RFI #: 163
 Date: 6/26/2012
 Job: EB-02 Keller Springs Lofts
 Phone: 877-777-5115

Subject: Steel Beam at SW Corner of Fitness

Request: Date Required: 6/28/2012
 It appears that the W18x46 beam (running north and south) connects to the W14x22 beam (running east and west). There are a couple of concerns/questions.
 1. The flanges on the big beam will have to be cut to "wrap" around the column, as it is about 6" wide. Please provide a detail.
 2. Please provide a detail to show the connection for the large beam to tie to the smaller beam.

1 TYPICAL DRILLED PIER DETAIL
S3.01 NO SCALE

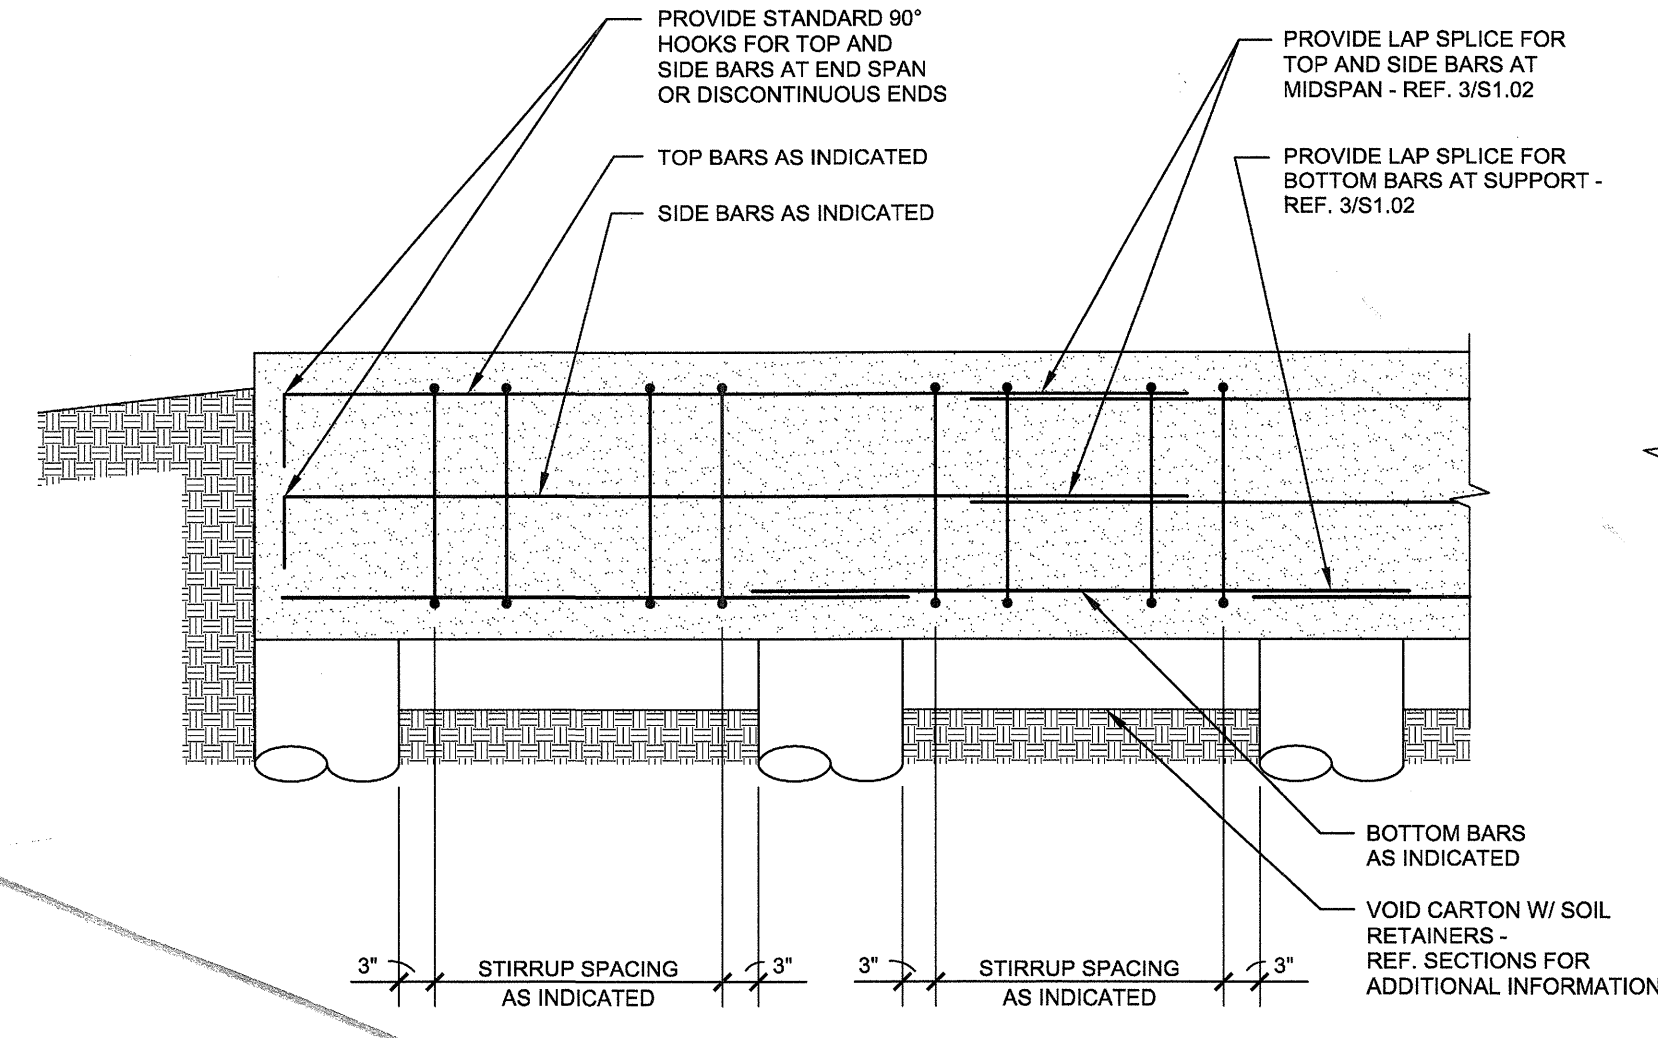
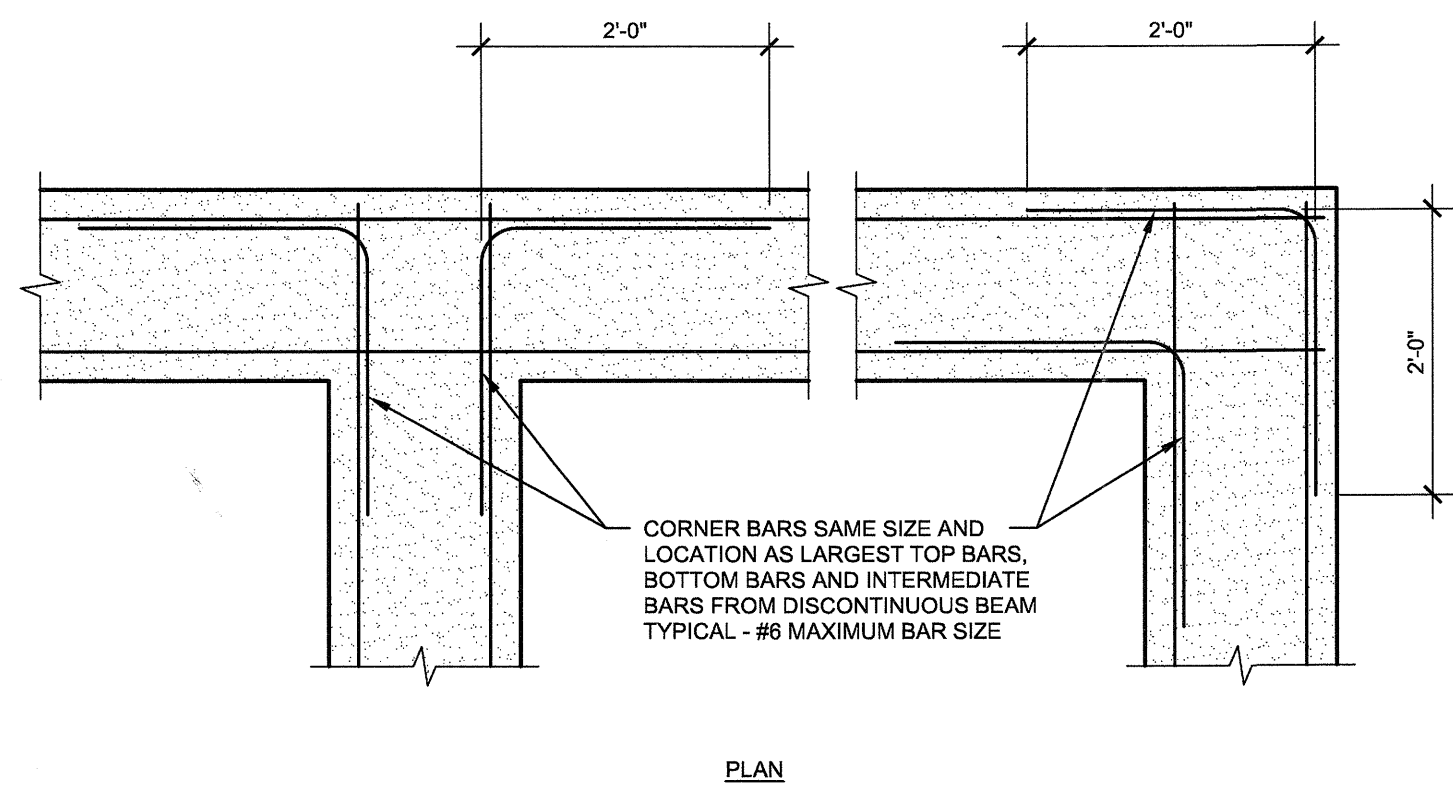
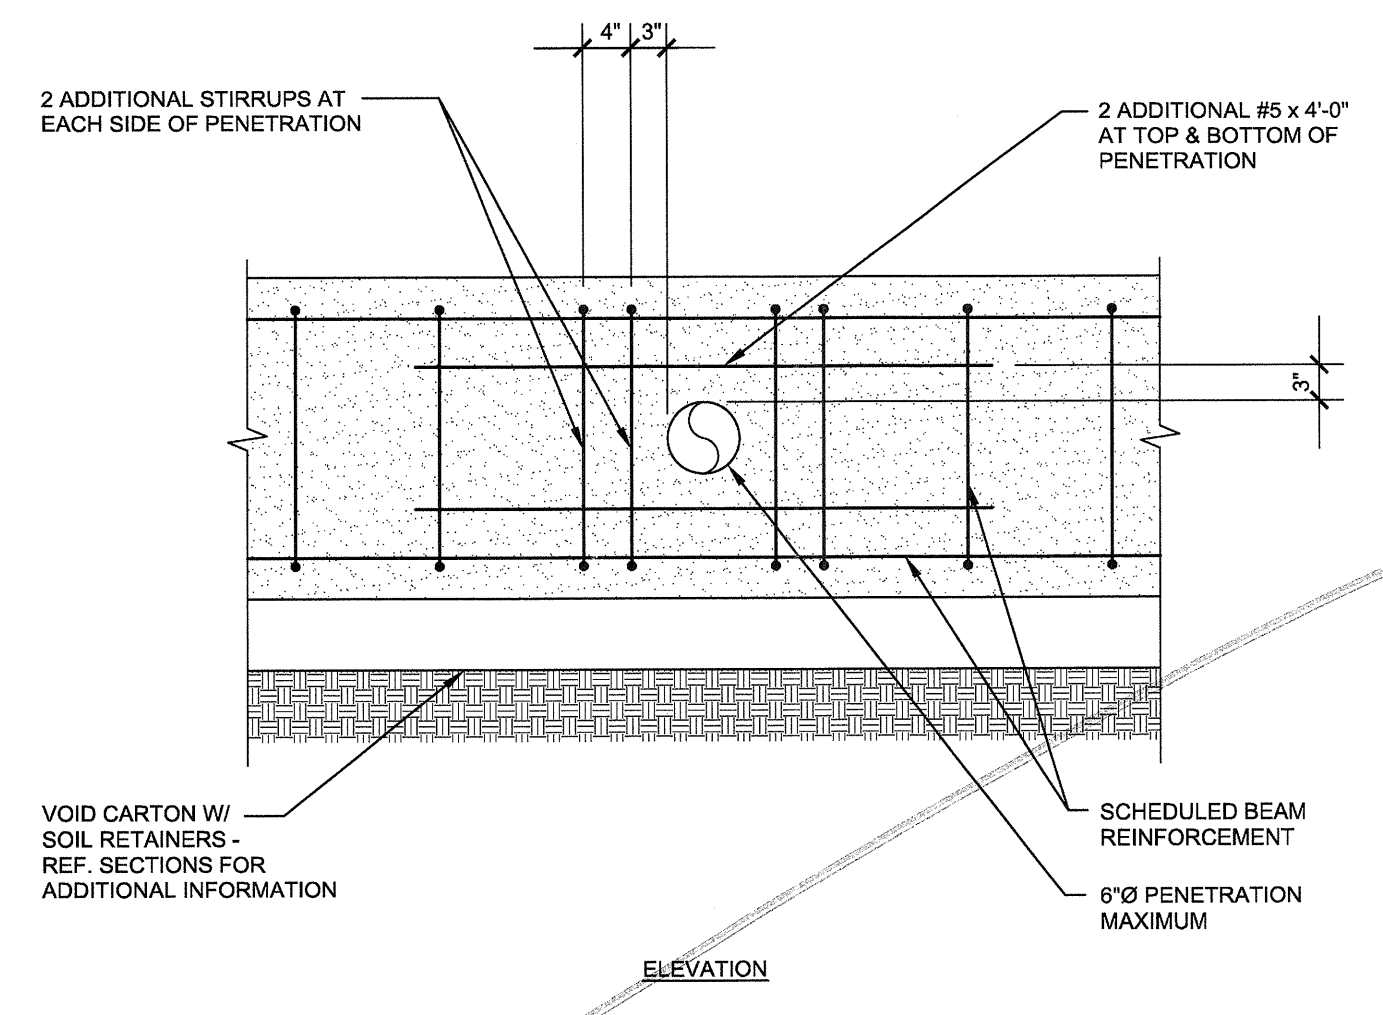
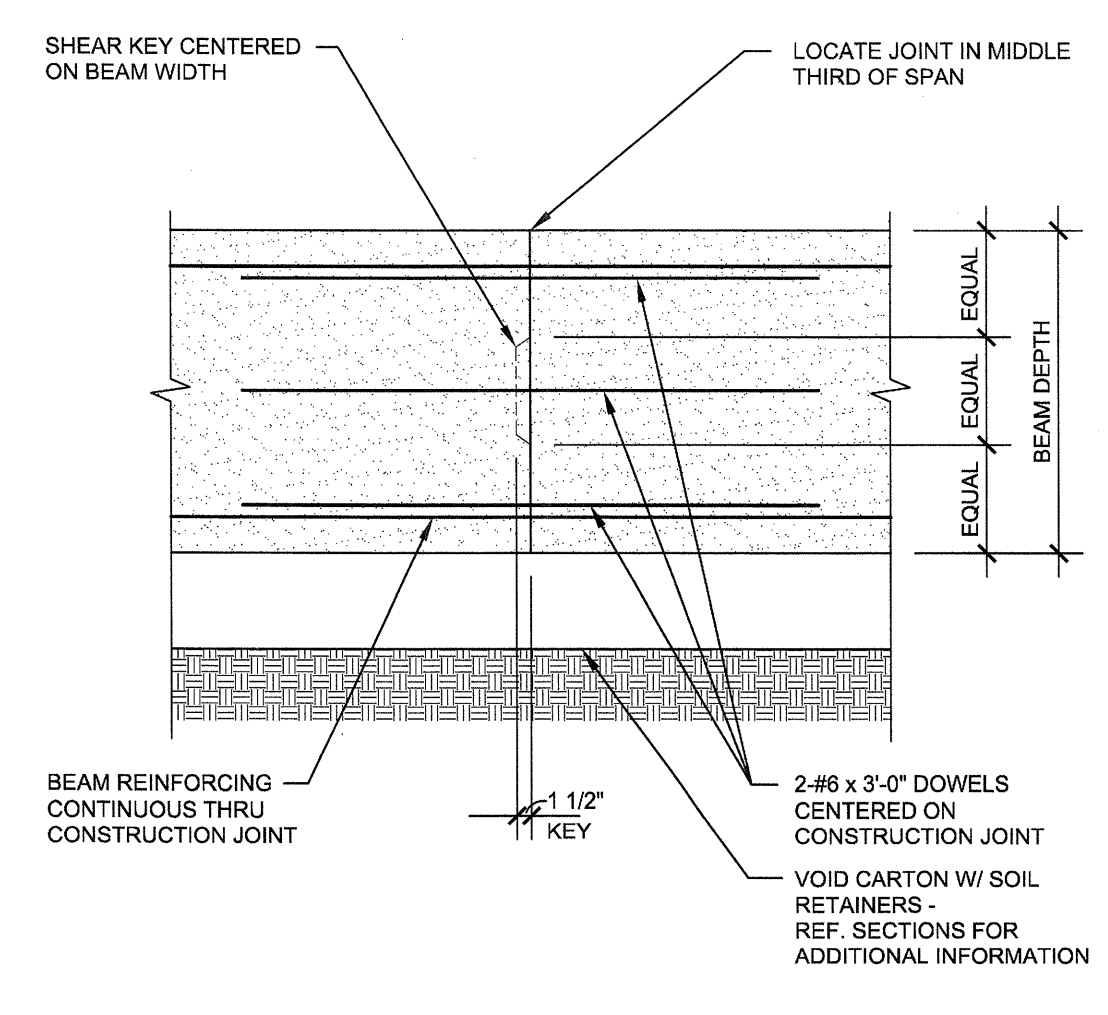
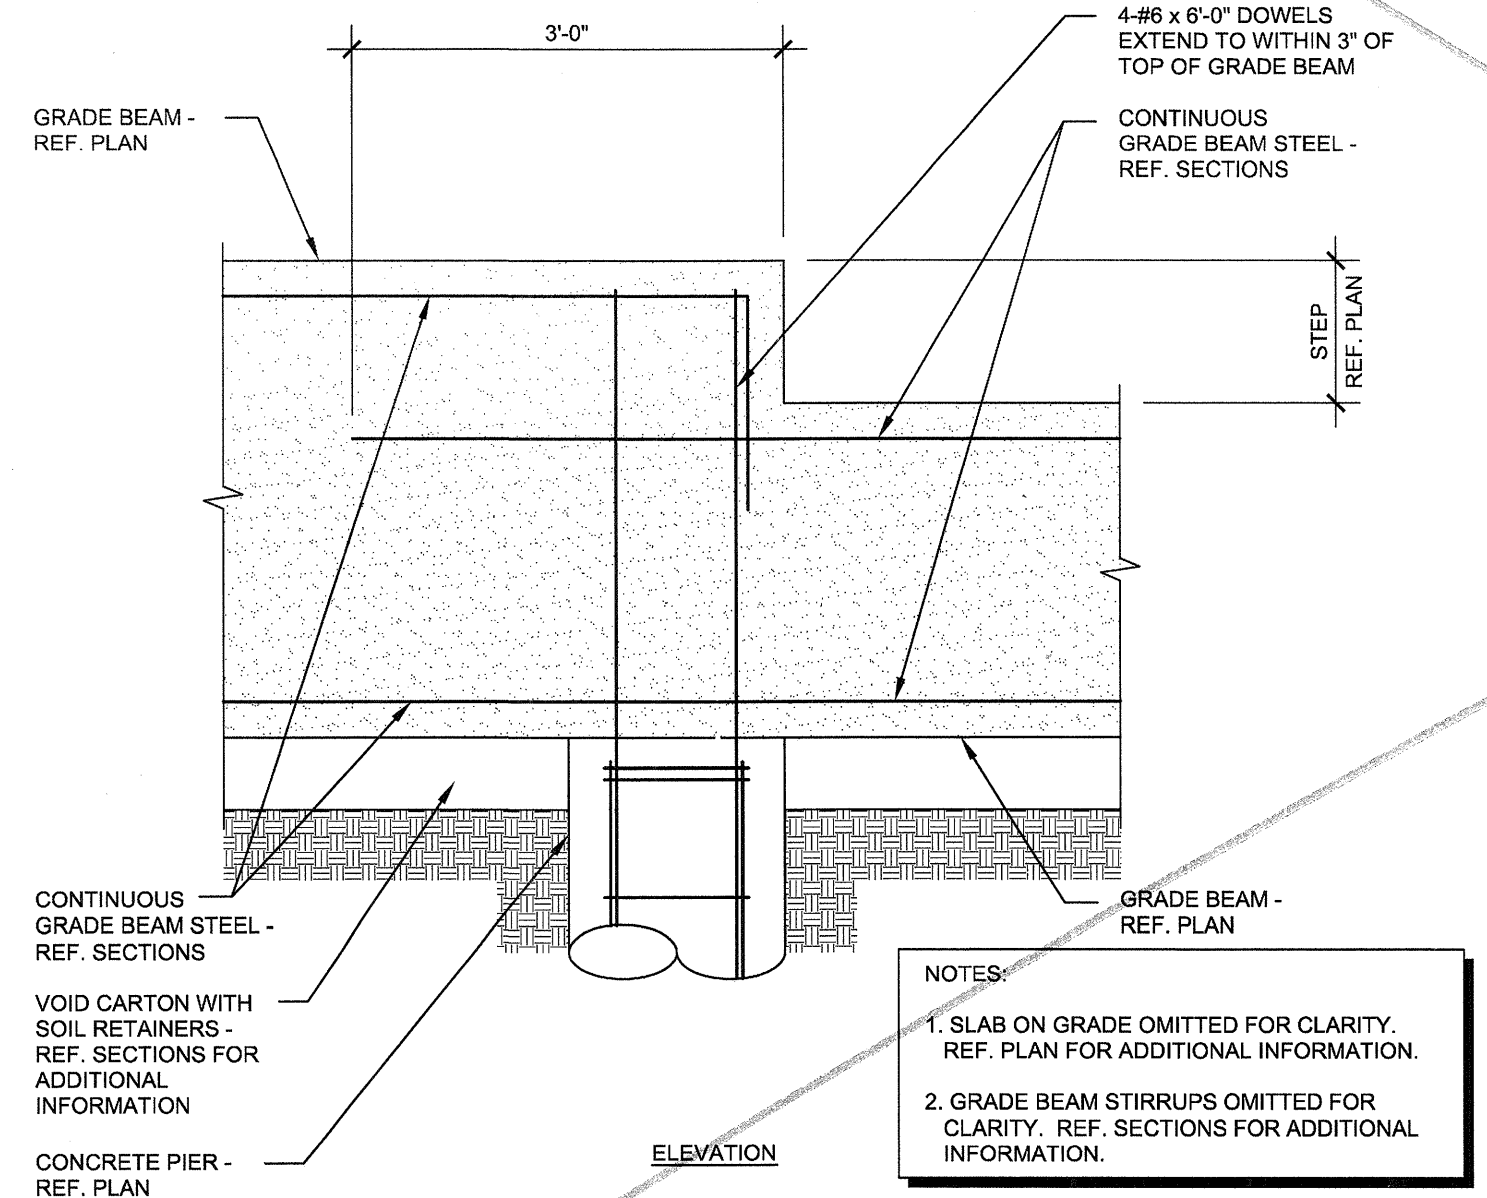
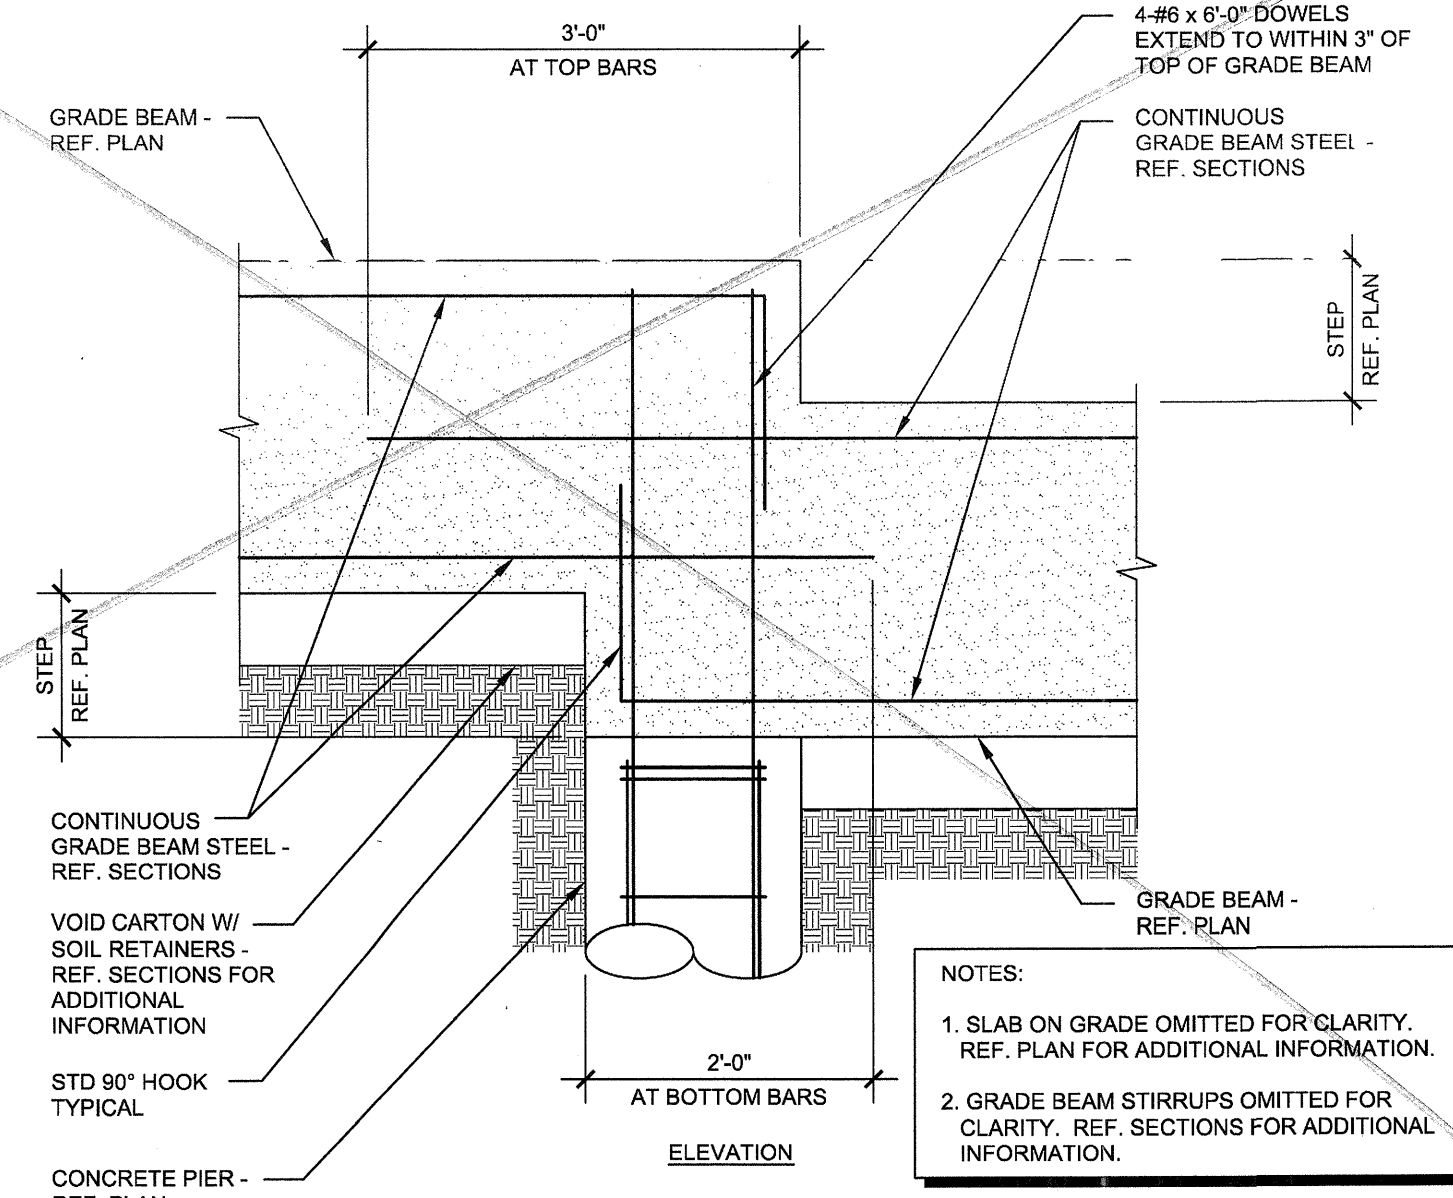
Request: Date Required: 2/6/2012
3/S3.02 shows typical drop panel detail (pier cap). We are confused and not sure of the proper steel size and placement. Are L bars being used and is it tied to the pier steel or dowels? Also, what is the size of the steel for L bars. Where plan shows #4 at 12" O.C. each way bottom, why is spacing on detail more than 12"? We need to have more clear information on the pier cap steel so we do it correct the 1st time, see attachments with comments.

Please see attached for bar placement and submit reinforcing steel shop drawings for approval.

Provide #4 at 12" on center in large areas. Provide #4 bars as indicated in detail 3/S3.02 at 6'-0"x6'-0" drop caps.
